**Consultation Response from KC,
Highways Development Management****2023/93704 land northwest of, Urban Terrace, Denby Lane, Grange Moor, Huddersfield, WF4 4EB****Erection of 10 dwellings and associated works****Date Responded: 24/05/2024****Responding Officer: Ryan Kinder****Responding Ref:K16-6/38**

RECOMMENDATION: Objection due to:

- refuse storage and collection being substandard.
- Internal layout not to adoptable standard.
-

1 Proposed Site Layout

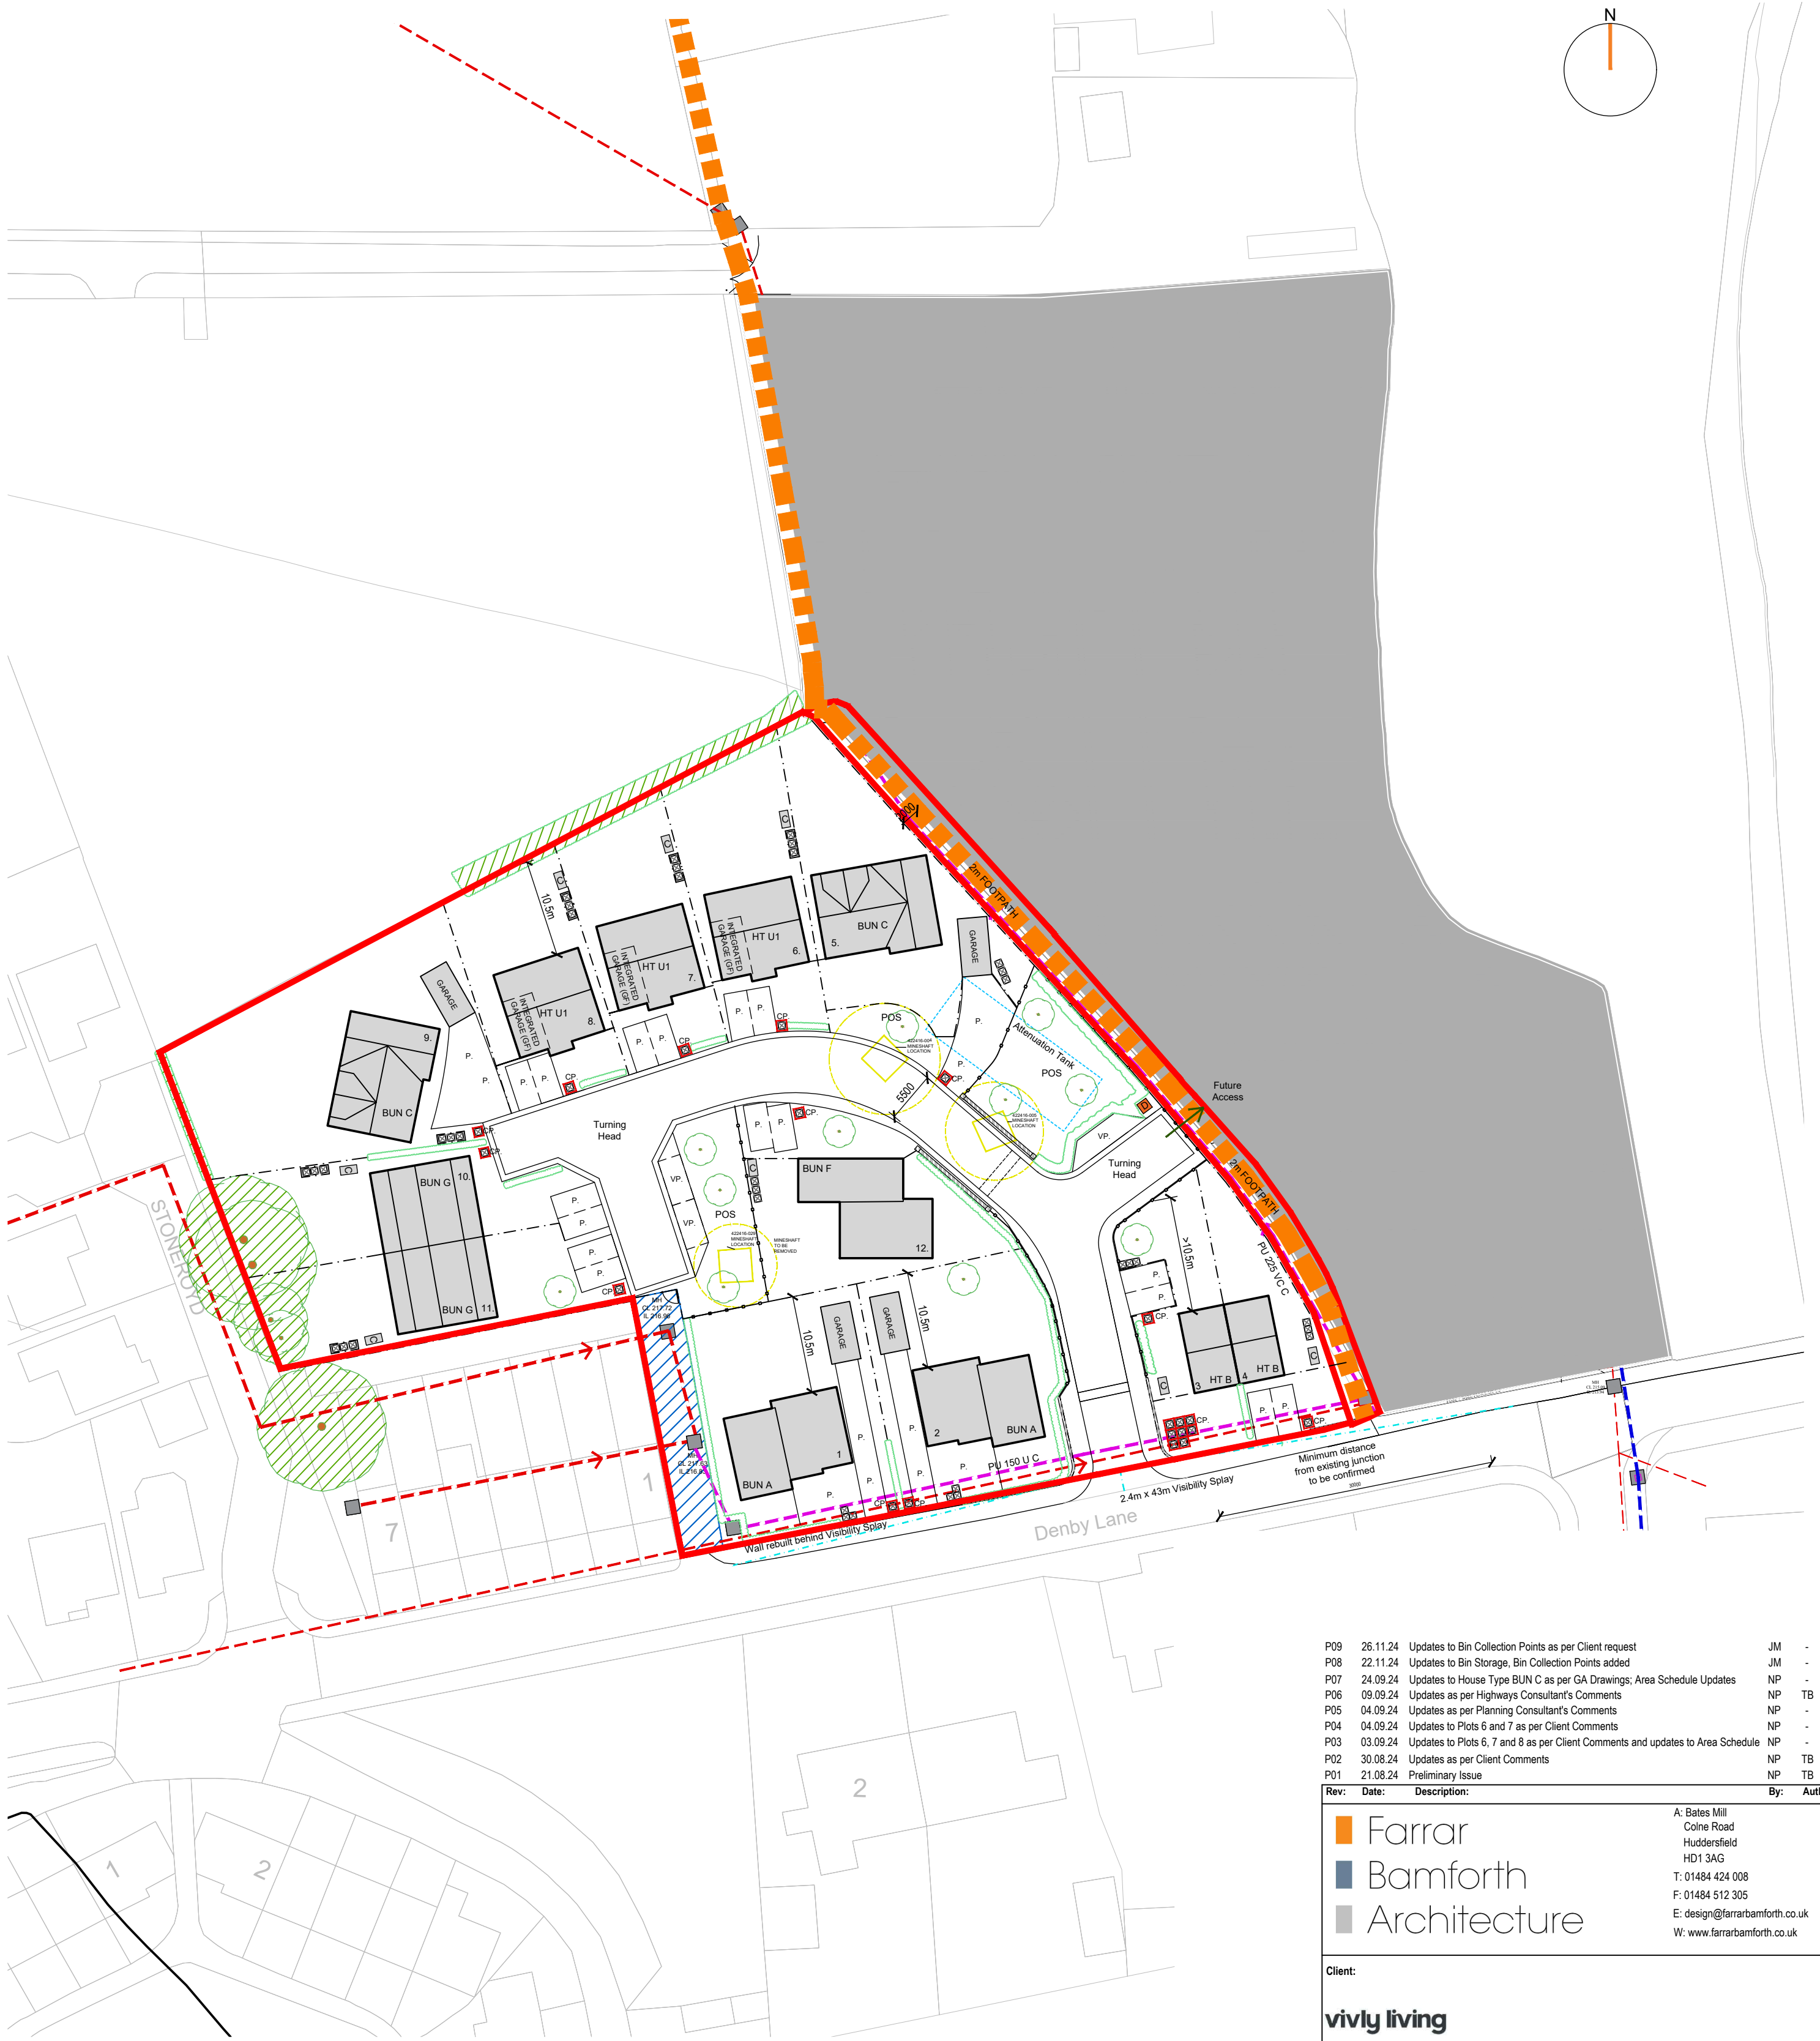
The applicant has advised that the internal layout will remain private, however this should still be built to adoptable standards, it is considered that the initial section of road up to the gated arrangements and round to the area marked for 'future development' should have 2.0m wide footways on each side and be of traditional estate road arrangement.

No information has been provided in terms of refuse collection, the current indicated refuse collection point for plots 4 to 10 is in excess of the adopted highway and therefore unacceptable, it is suggested that the initial section of road be adopted and suitable swept paths demonstrated for a refuse collection vehicle. Or a bin collection point located adjacent to Denby Lane to serve the development as a whole. The bin collection point for plots 5- 9 is also in excess of the adopted highway and considered unacceptable.

The gating off of the private road raised concerns for emergency service vehicles, it is recommended this element be removed.

It appears an acceptable level of off street parking is provided for each dwelling, confirmation of parking space sizes for each dwelling and garage sizes is requested.
